I am writing on behalf of the British Horse Society (BHS) a membership charity with over **125,000** members representing the UK's **3 million** regular riders and carriage drivers, in response to the Light Valley Solar Ltd Project. The BHS is the largest and most influential equestrian charity in the country, working to improve the lives of horses and their owners through its four core foundations of education, welfare, safety and access.

**The BHS objects to the DCO.** The BHS objects to this application on the grounds that the application does not meet the tests of NPPF Paragraph 105. The BHS objects on the grounds that equestrians are being marginalised in the scheme with walkers and cyclists being favoured. Throughout this scheme equestrians are excluded, the arguments for inclusivity of walkers and cyclists can be extended to equestrians using the mechanism of the Equality Duty. This is a form of discrimination, and the Equality Act 2010 created a Public Sector Equality Duty for authorities to provide equal opportunities for all, which means that an authority needs a cogent reason for excluding equestrians.

Scale at A3 <b>1:25,000</b>	Rev <b>P01</b>
Project Number <b>302939-00</b>	
Drawing Number <b>EN0110012/APP/LVS/06.02.13.03.05</b>

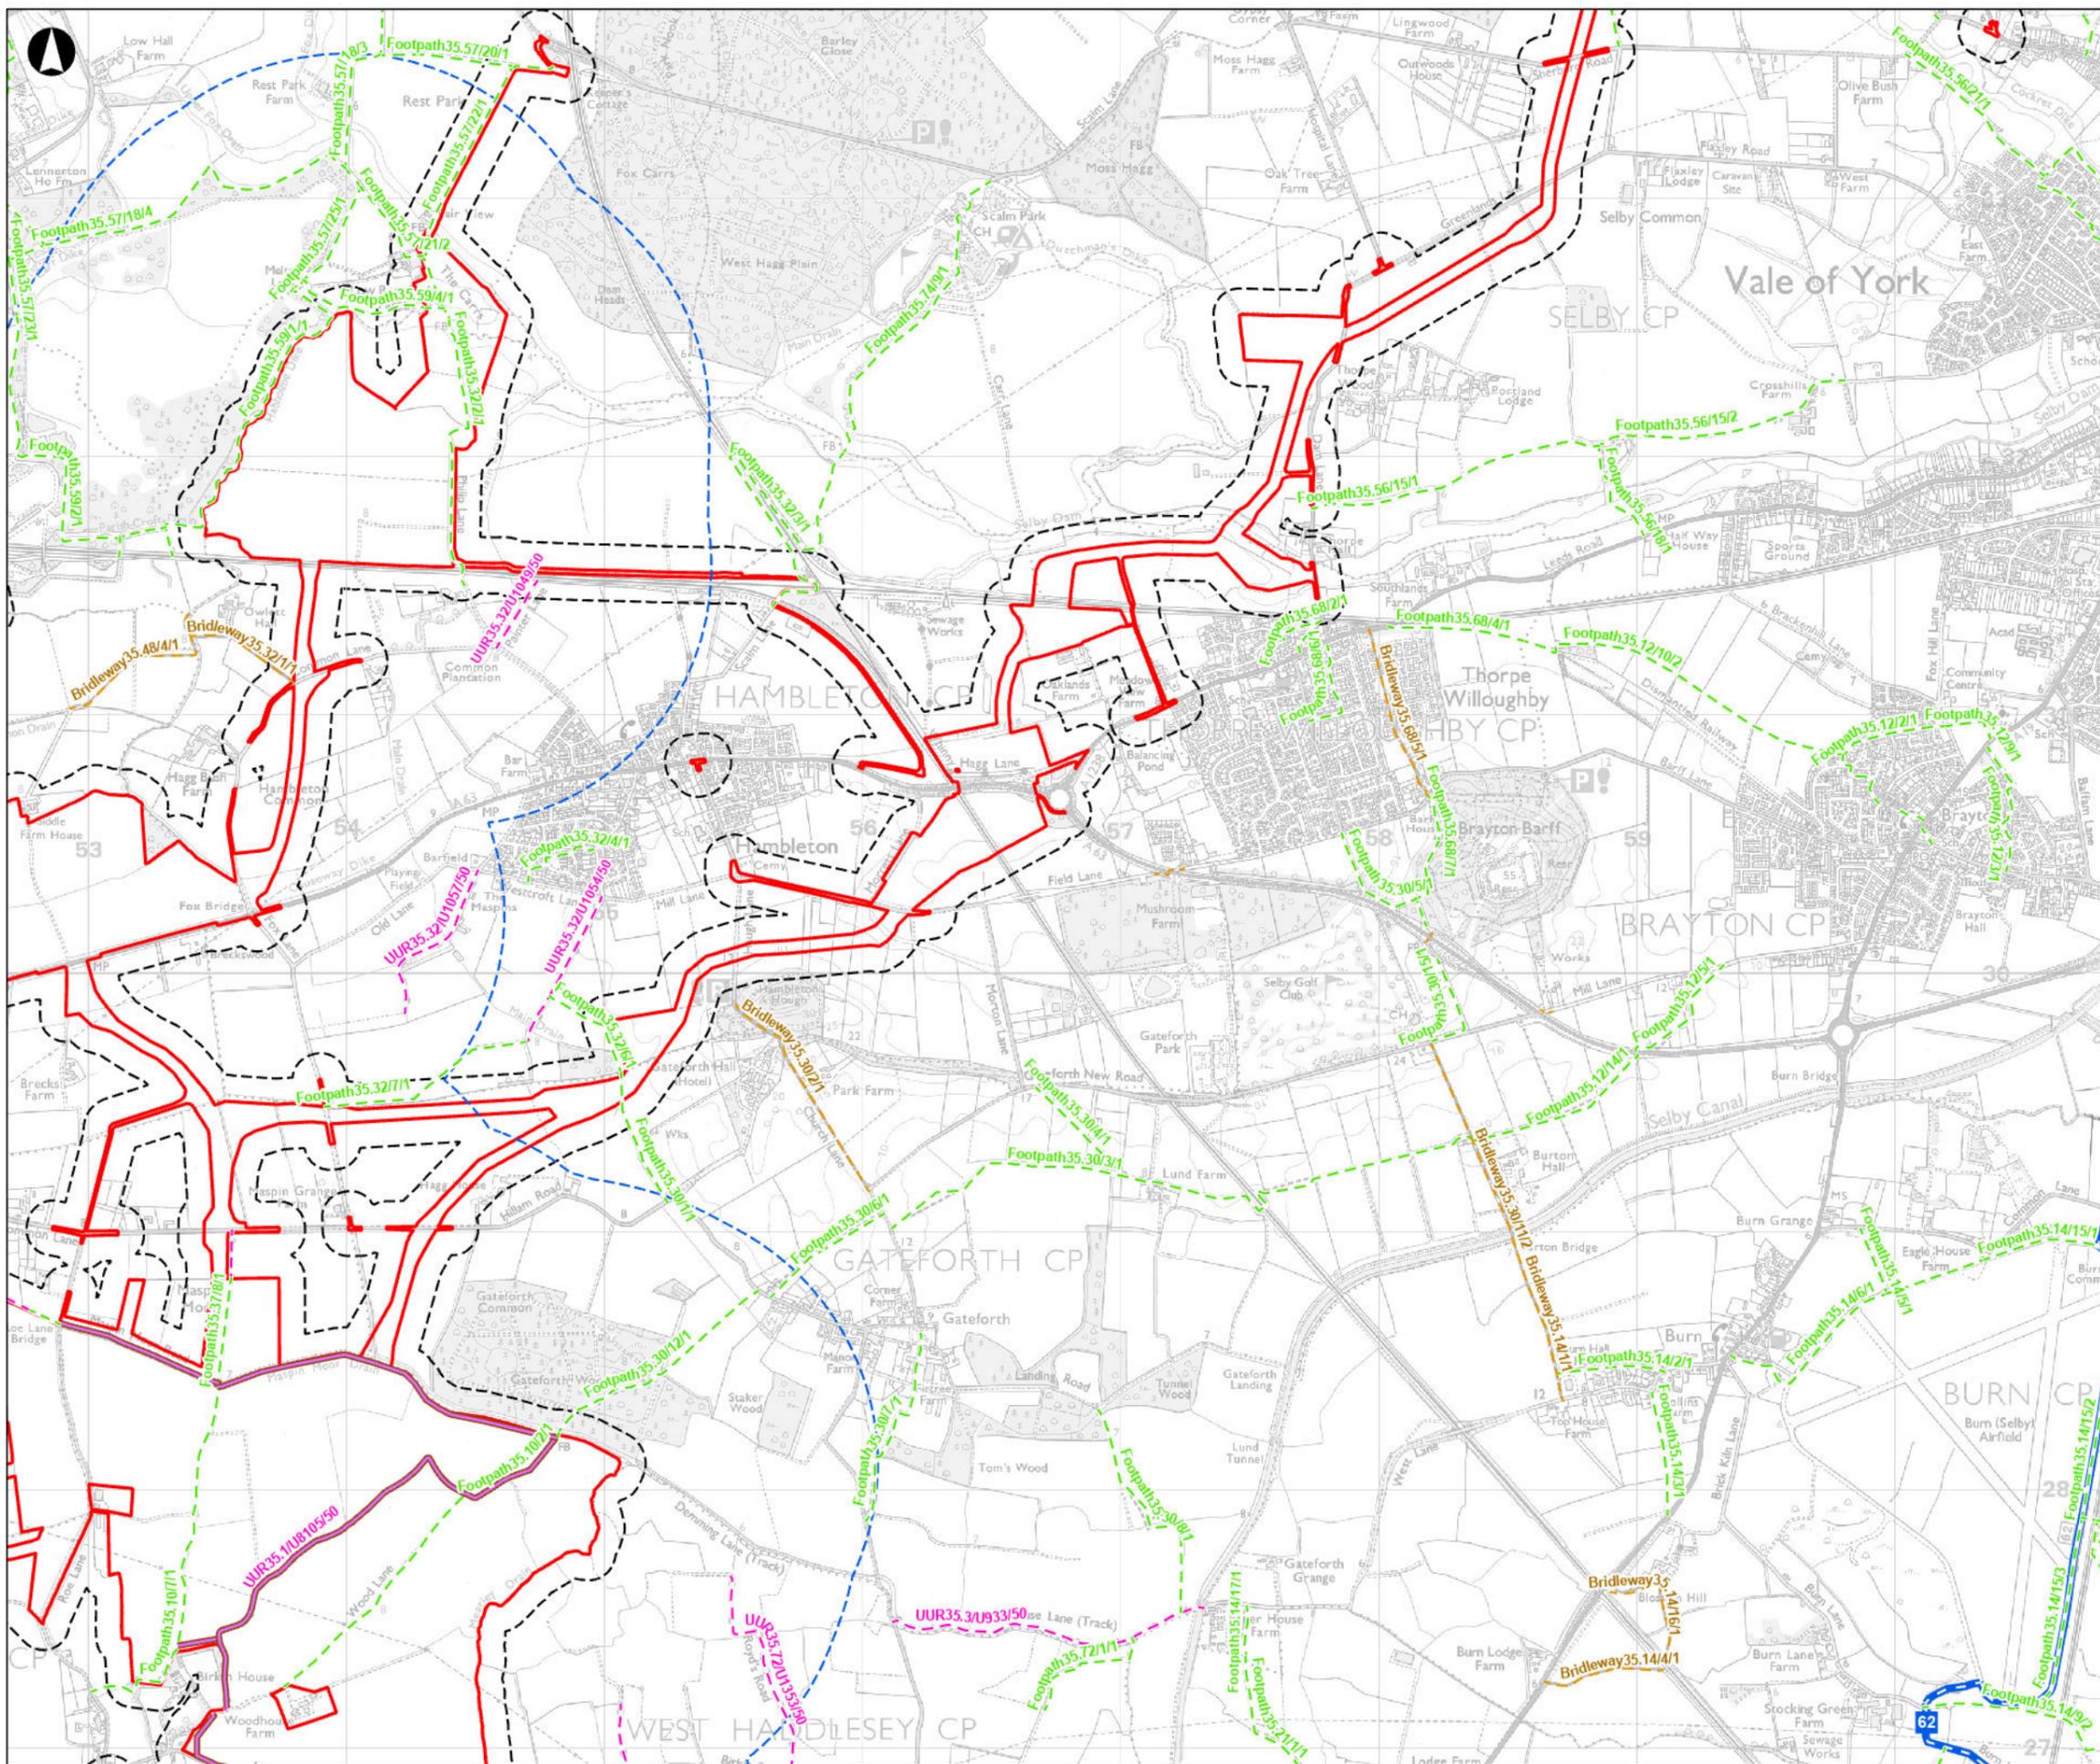
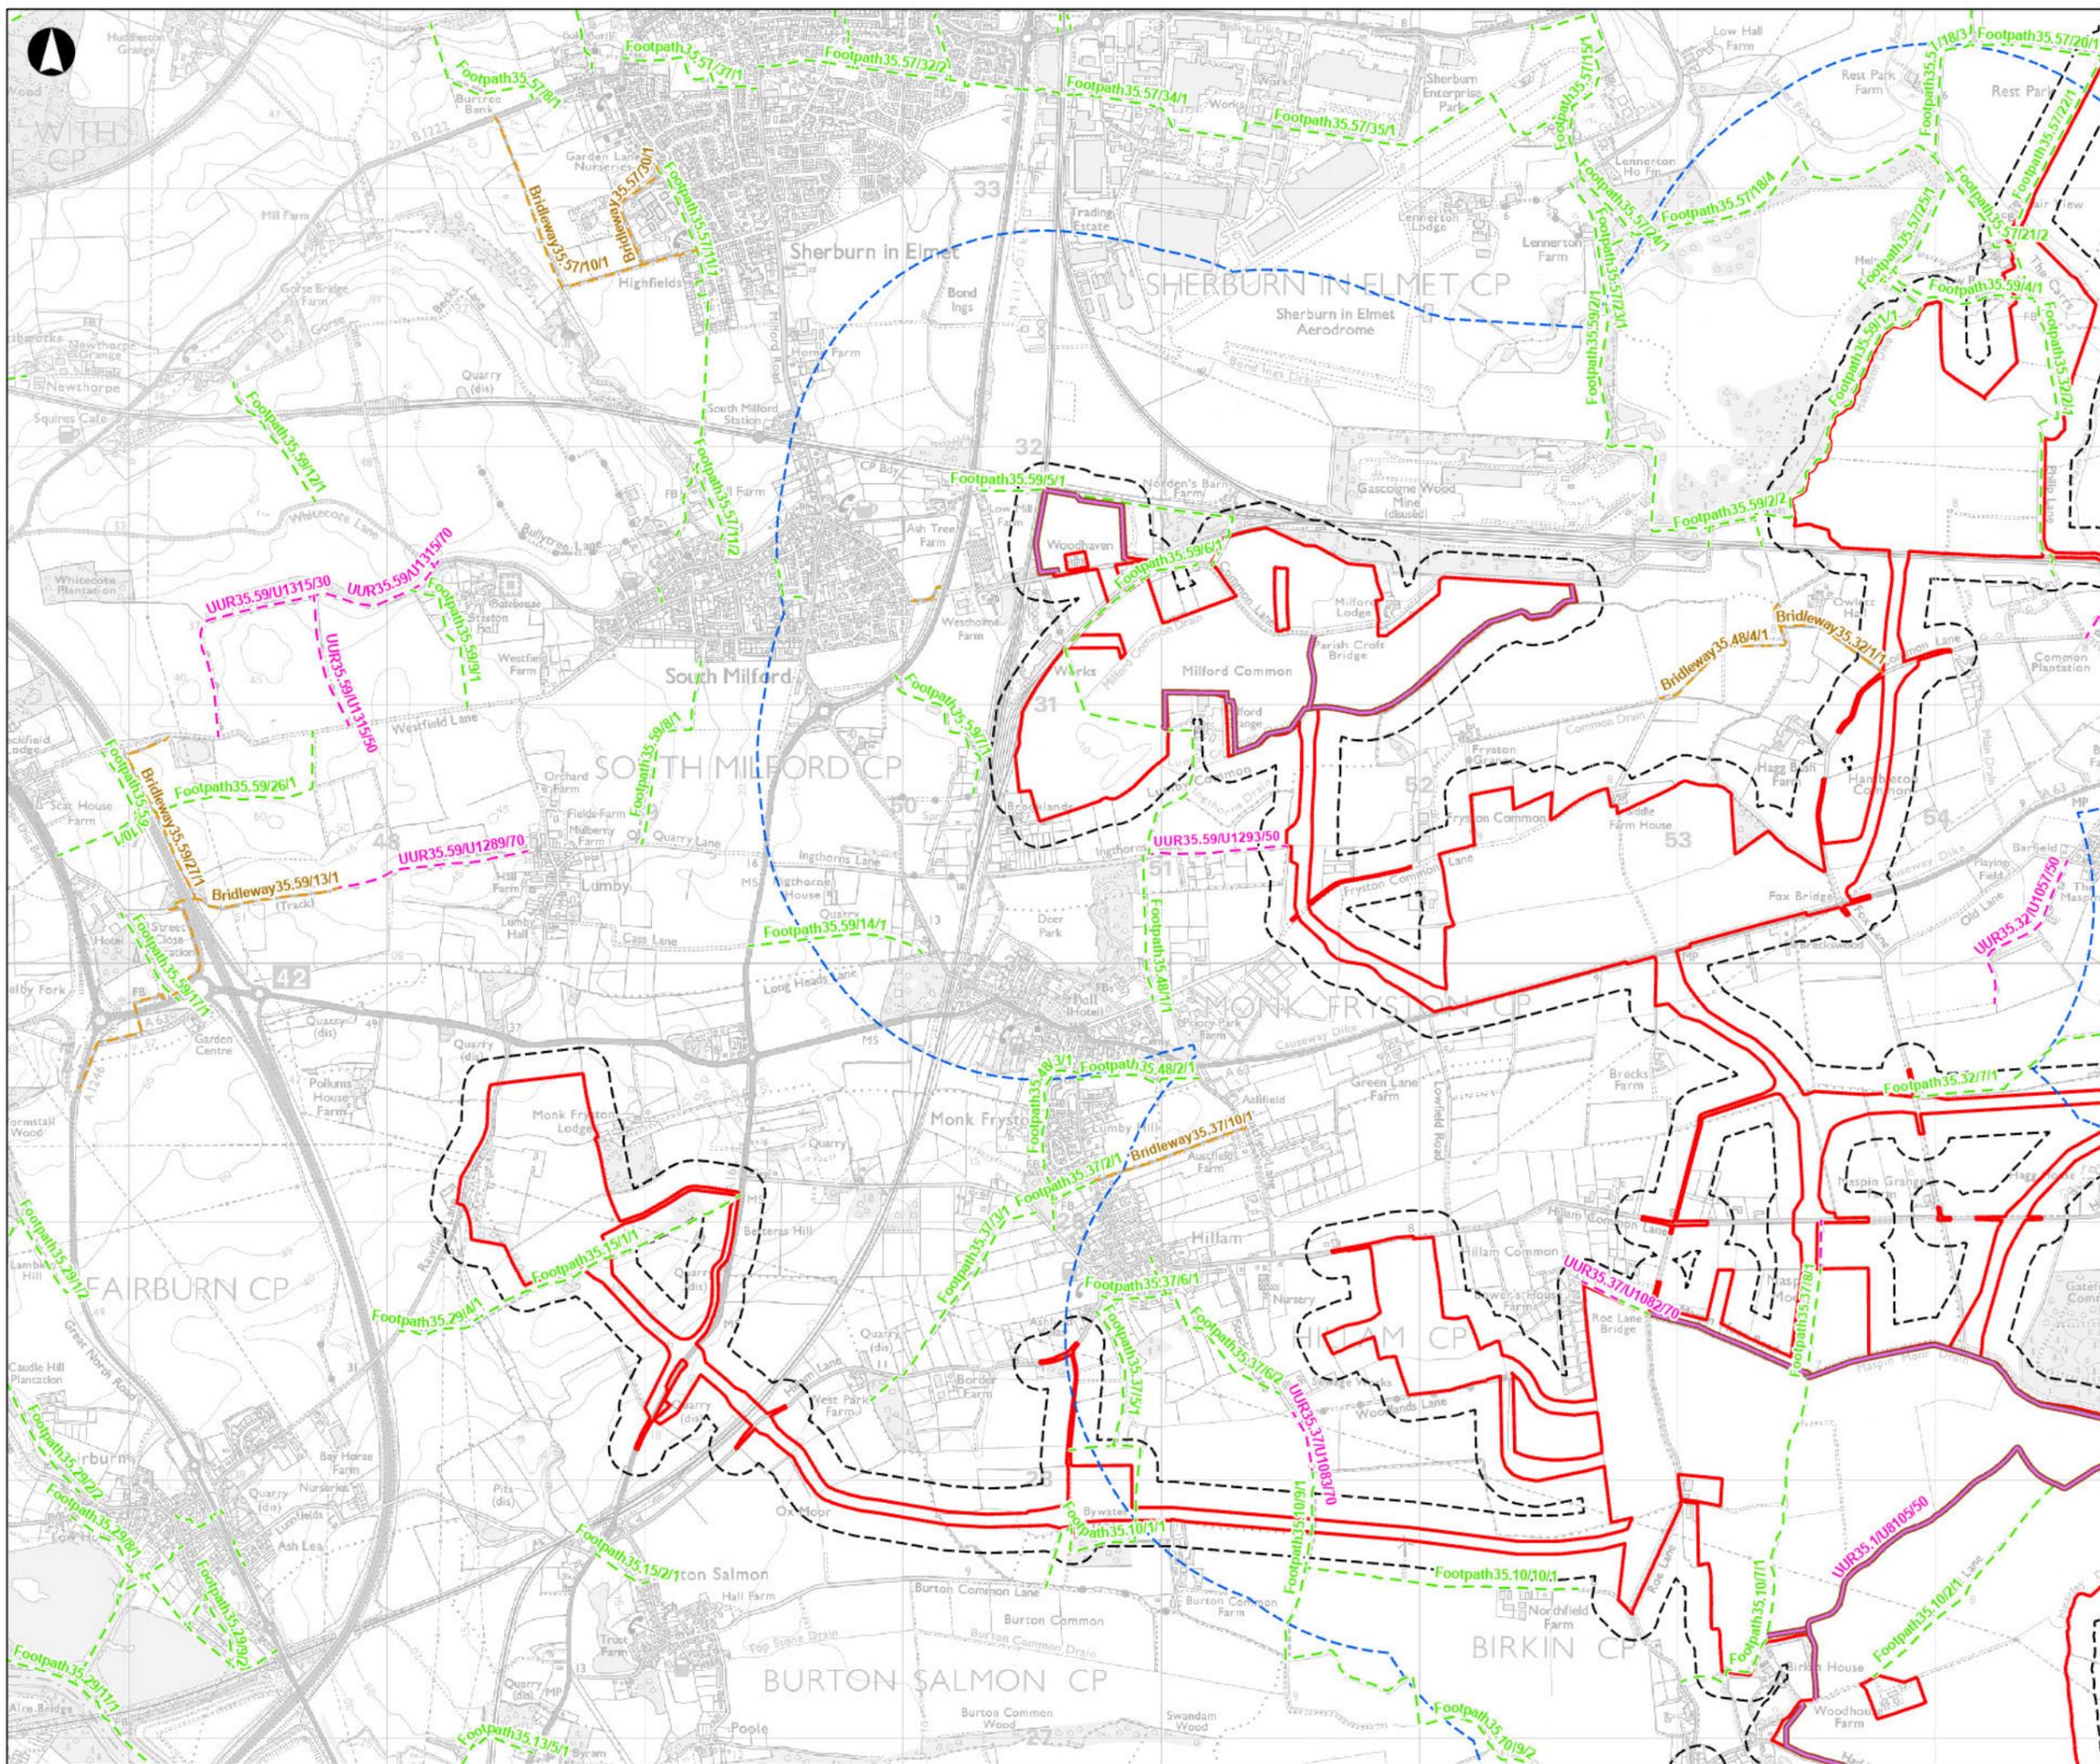
Permissive paths should be multi-user and made available for all NMU users not just walkers and cyclists it should be noted that cyclists can legally use bridleways it therefore makes more sense that these permissive paths be multi-user.

The distances of Permissive paths within the scheme are shown as a mere 8km which does not seem appropriate for a scheme of this size. We would like to see the distances available to each user group broken down by length, IE permissive path length available to Pedestrians separated from both cyclists and horse riders.
